Your Ref :
Our Ref : M/11/13/NMA

Section 96A of the Town & Country Planning Act 1990 (as amended)
Town and Country Planning (Development Management Procedure) (England) Order 2010 (as amended) - Article 9

Application for a non-material amendment following a grant of planning permission M/25/11/ to add weatherboarding above first floor level to gables in lieu of painted pebbledash and widen rear patio doors.
Yellow Hammers, 24 Sea Lane, Middleton on Sea,

Drawing
Elevations
Building Regulations

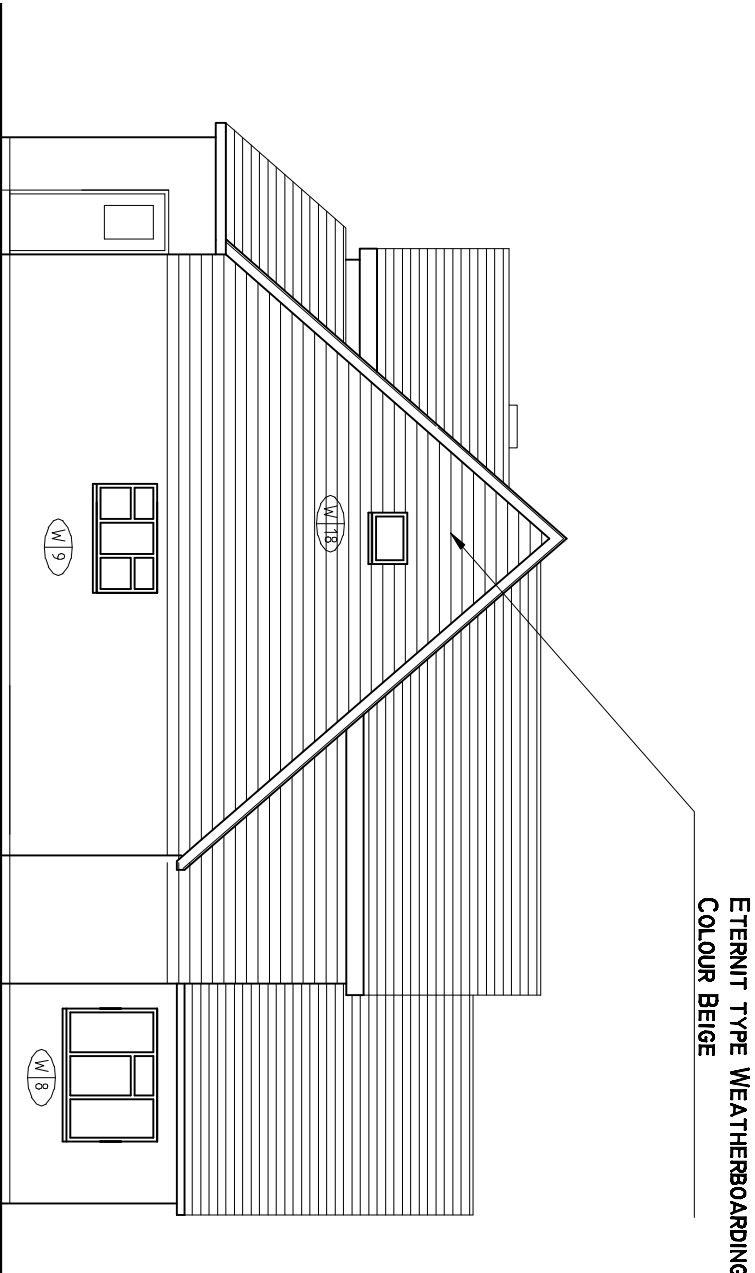
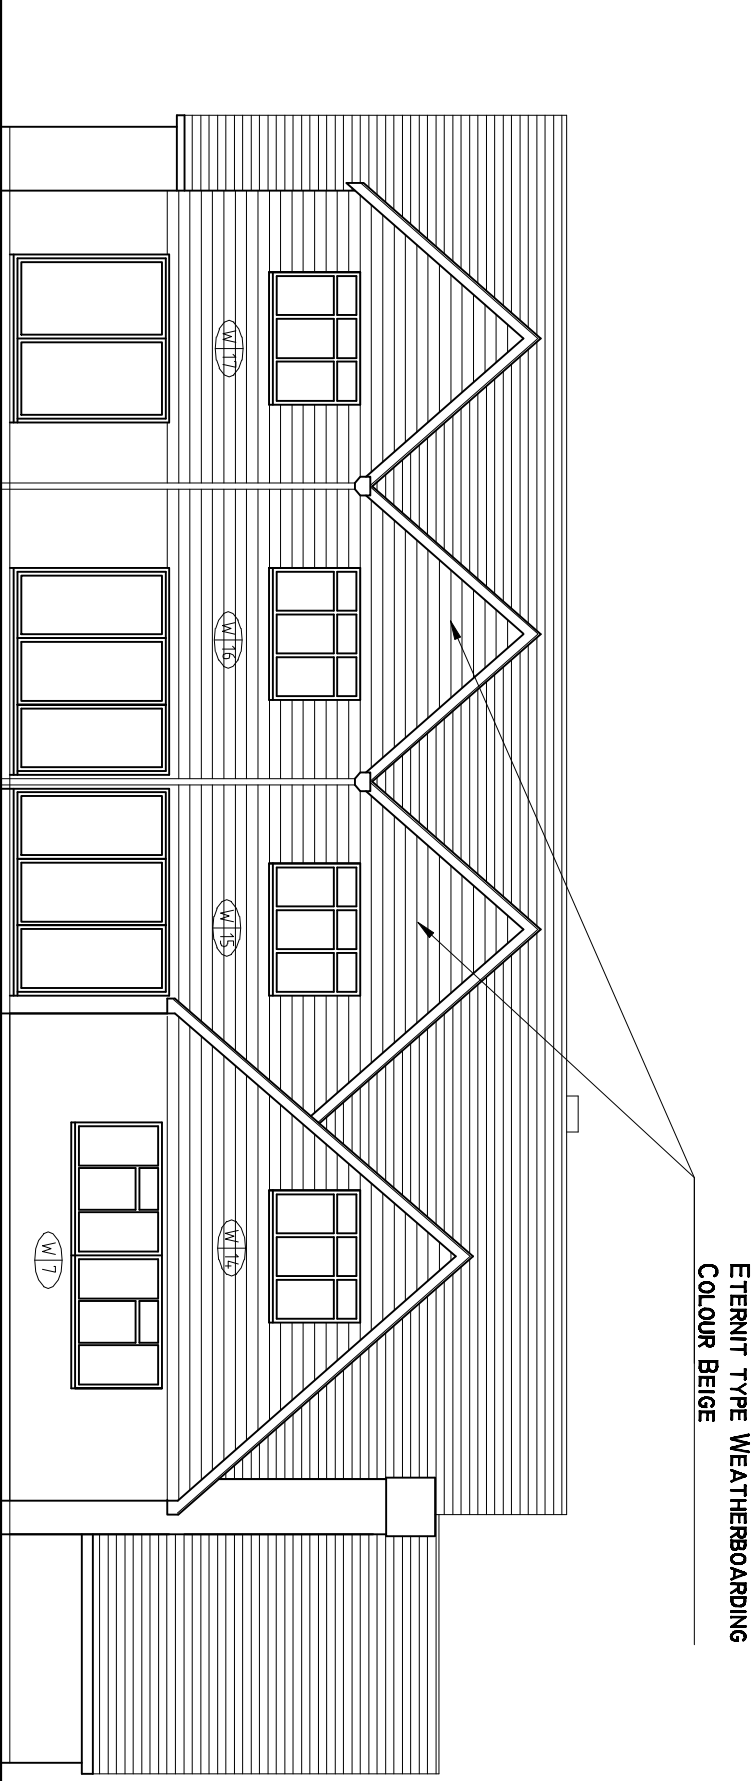
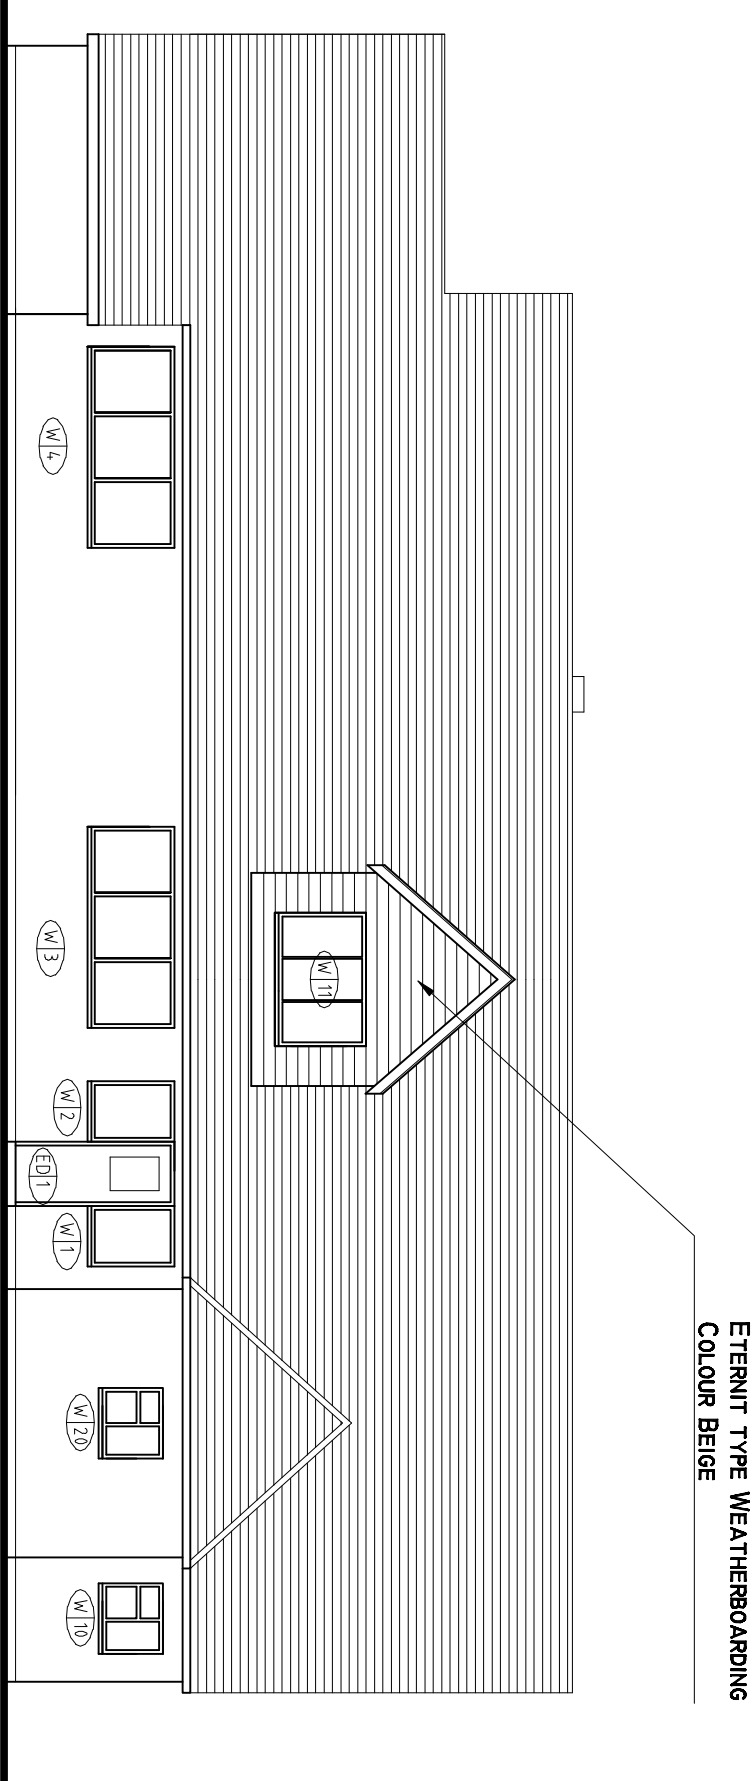
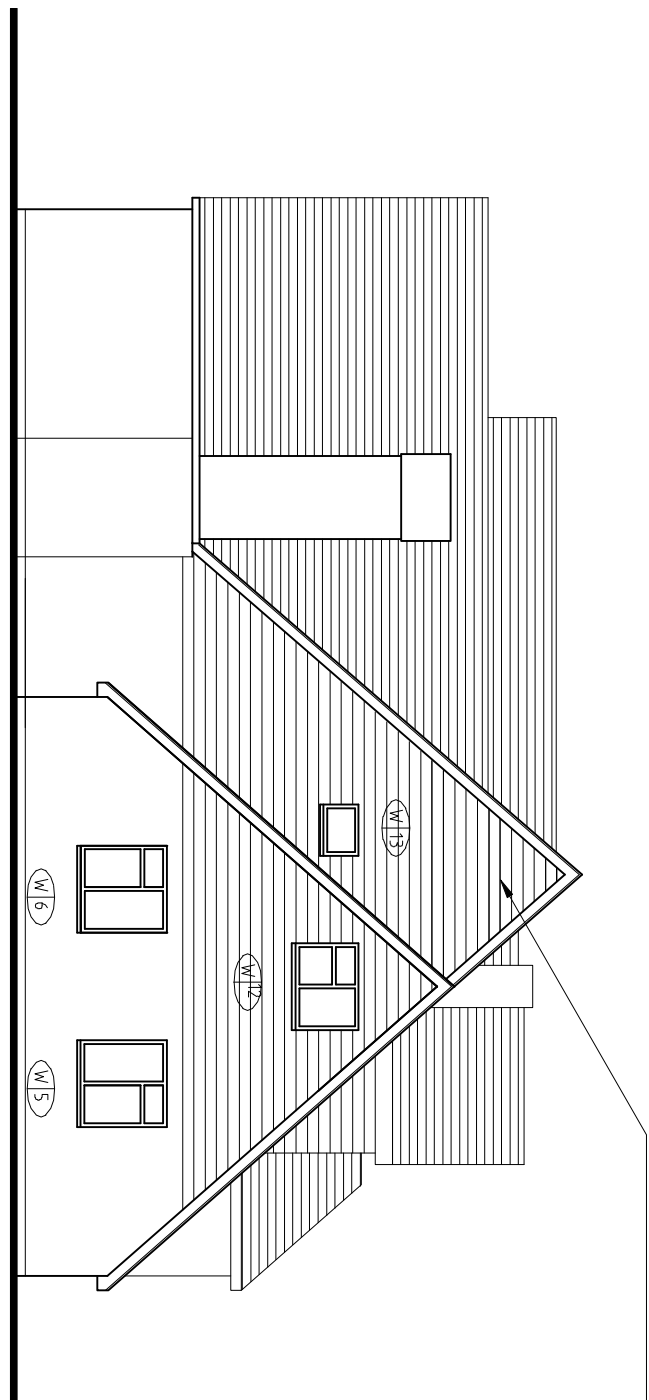
I refer to your recent application for a Non-Material Amendment. From the information submitted I am satisfied that the amended materials are characteristic of the surrounding area and appropriate to the dwelling and the changes to openings will not result in an adverse amenity impact to any neighbouring property. I will accept the alterations as a Non-Material Amendment to M/25/11. The corresponding new plan numbers are BR-01 Revision 03 and BR-02 Revision 04 both dated 18/02/13.
